Our Ref: AWE200083-L01: BCP/bcp
Contact: Dr Brett C. Phillips

22nd February 2021

RESPONSES TO FLOODING SUBMISSIONS, ASPECT INDUSTRIAL ESTATE, KEMPS CREEK, NSW

Figure 32 500 yr ARI Flood Extents and Flood Levels - Stage 1 Conditions

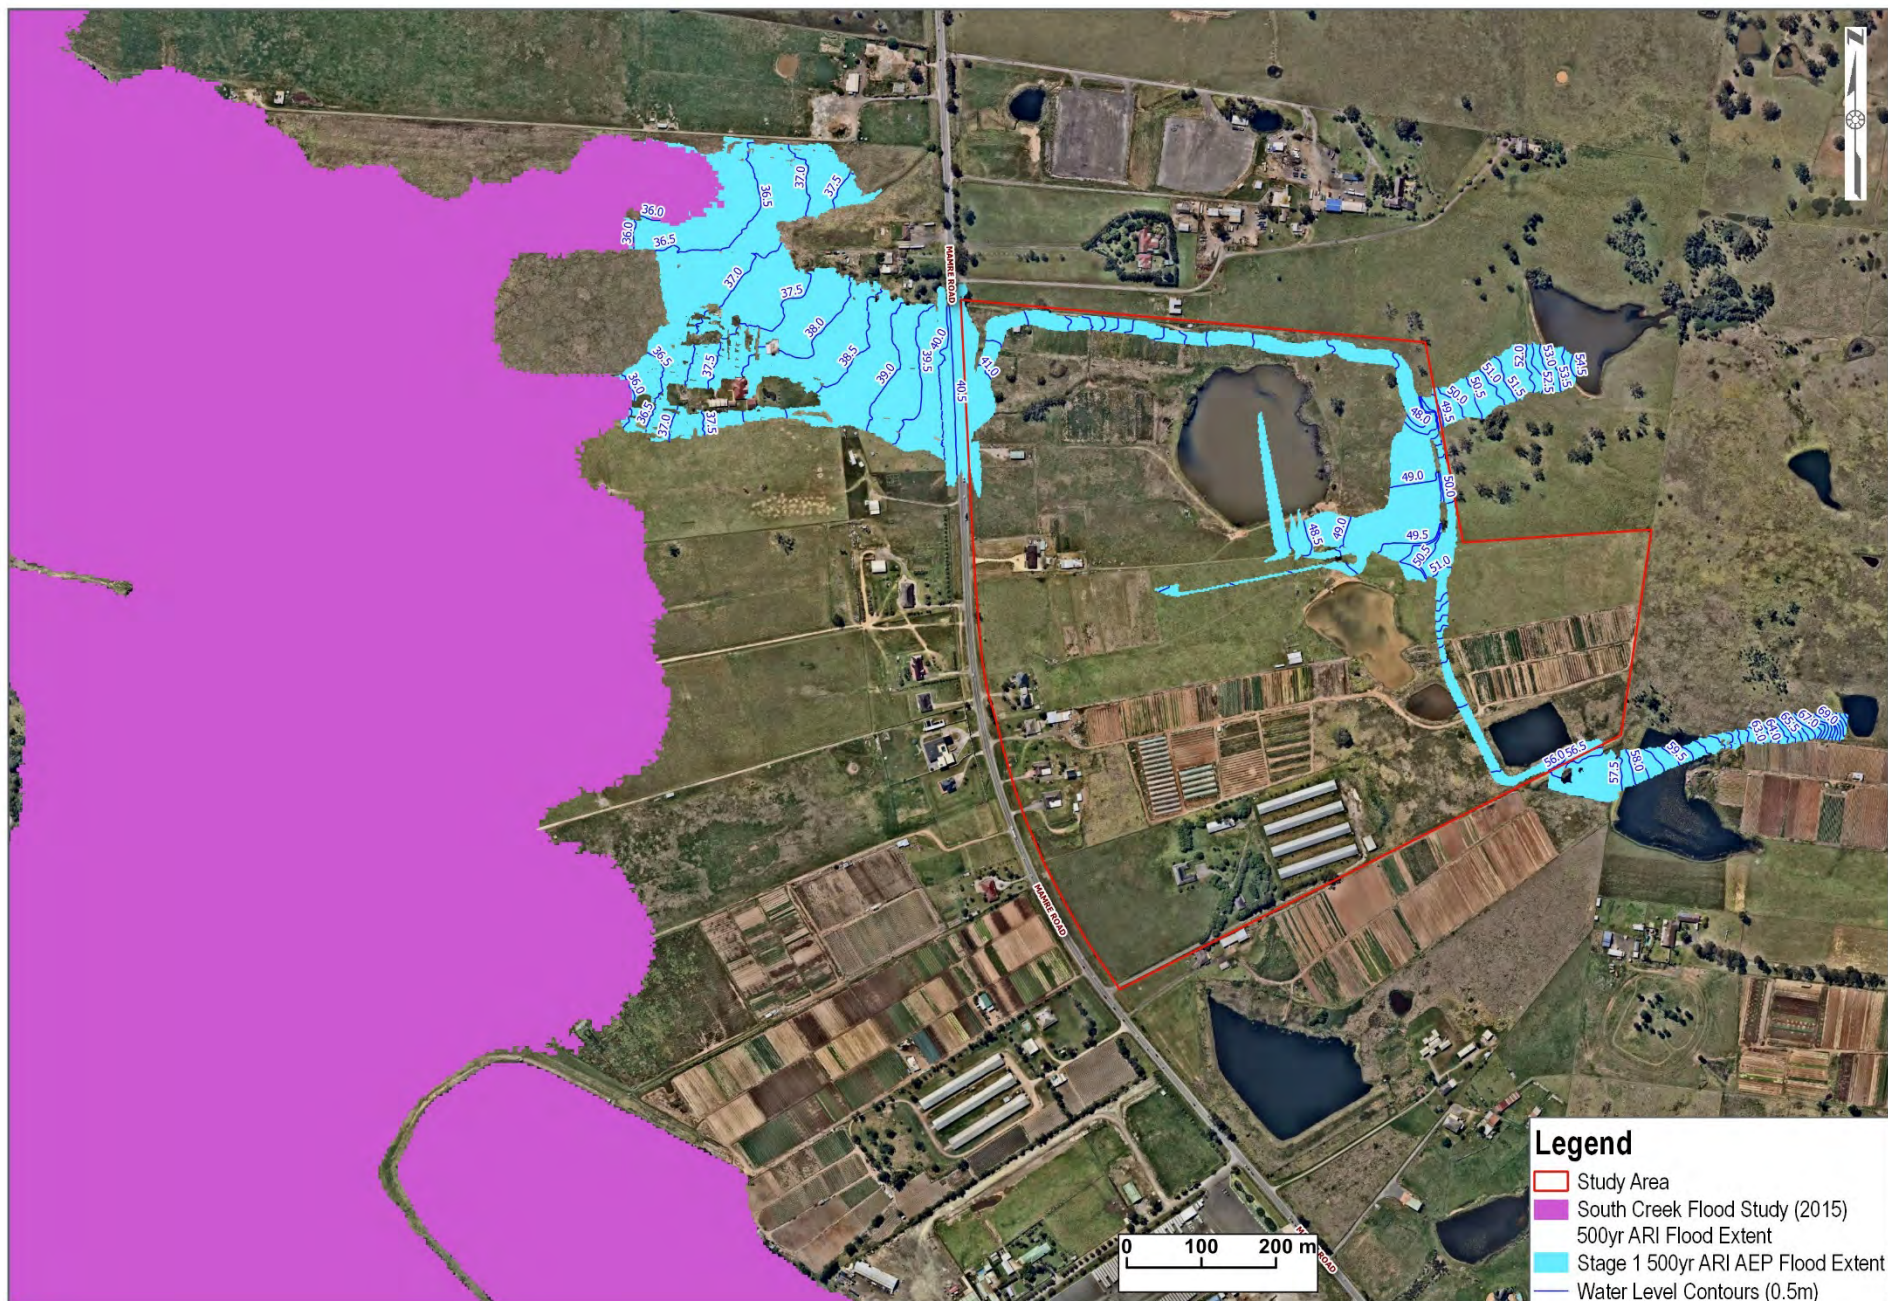
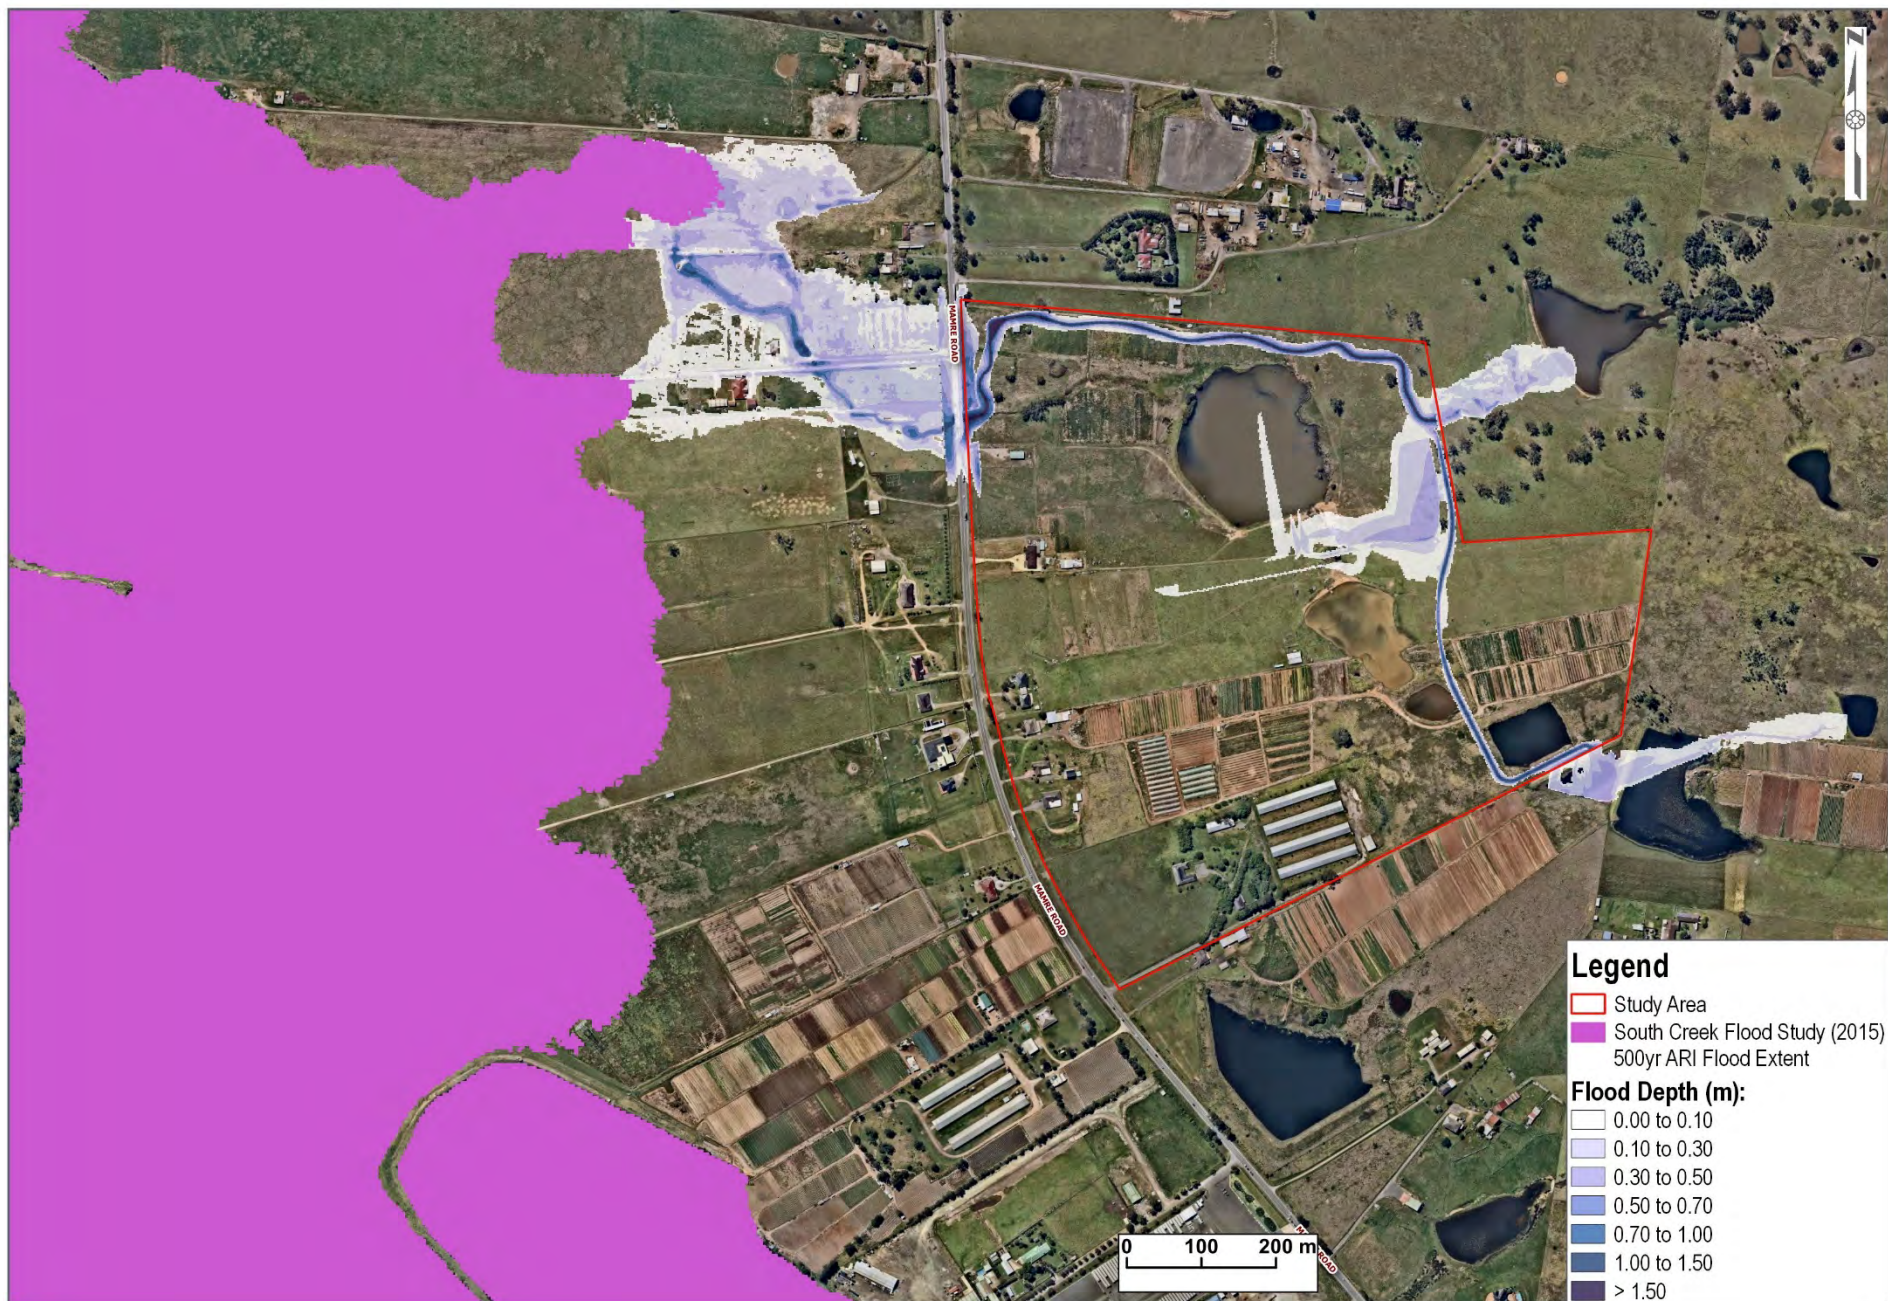
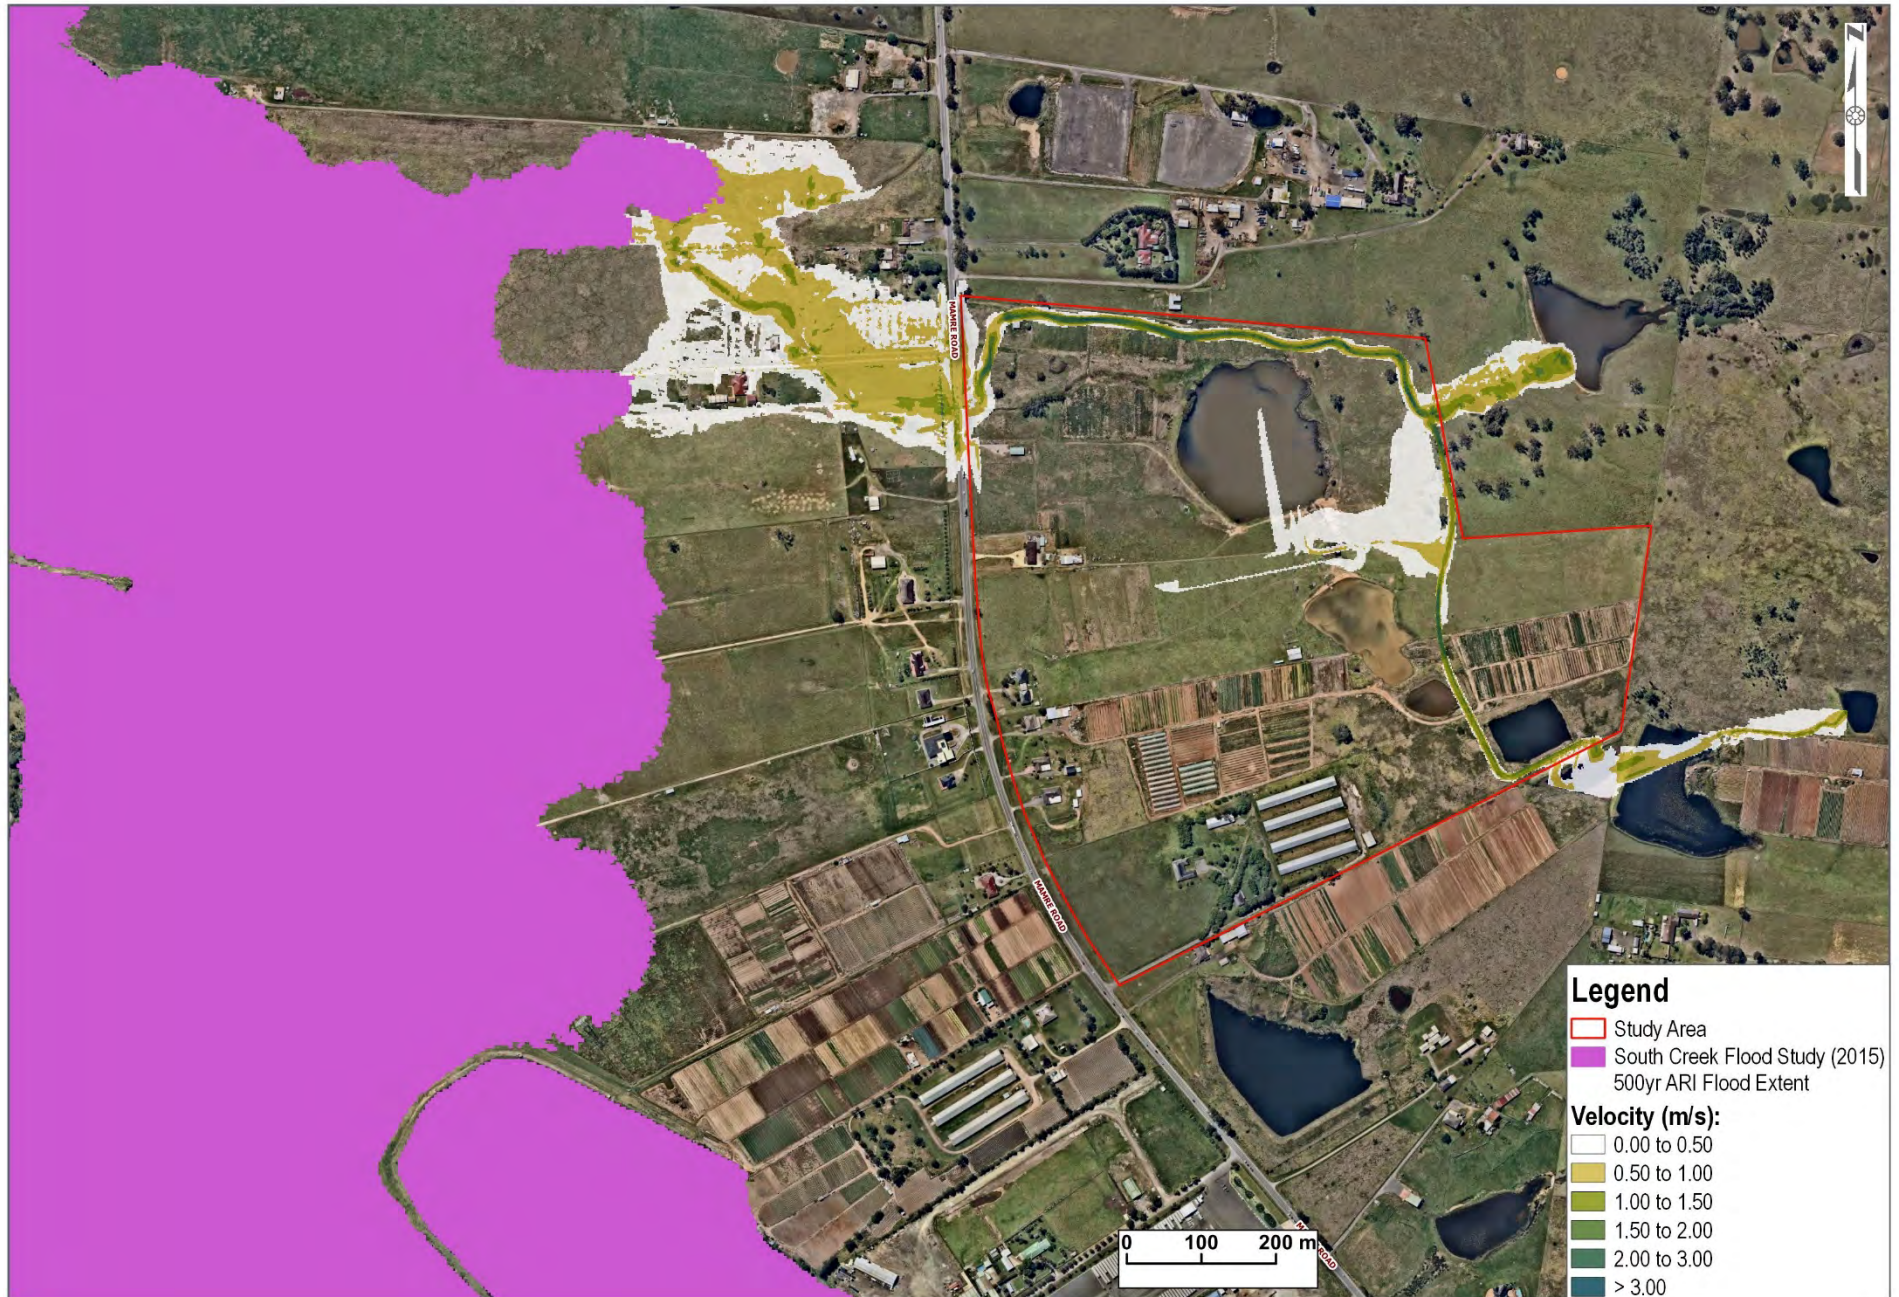
- *The developed scenario maps present local overland flow for Stage 1 which comprises of two industrial lots on the northern part of the site. However, from a flow management perspective, an overland flow study should consider the ultimate developed scenario of the site instead of considering each progressive development independently.*

- *All maps for developed conditions should properly depict the layout of the development, locations of proposed constructed channels and the location of the proposed detention basin.*

The final masterplan has been assessed and the results of the assessment have been incorporated into an updated version of the FIA report.

The updated Figures have been incorporated into an updated version of the FIA report.
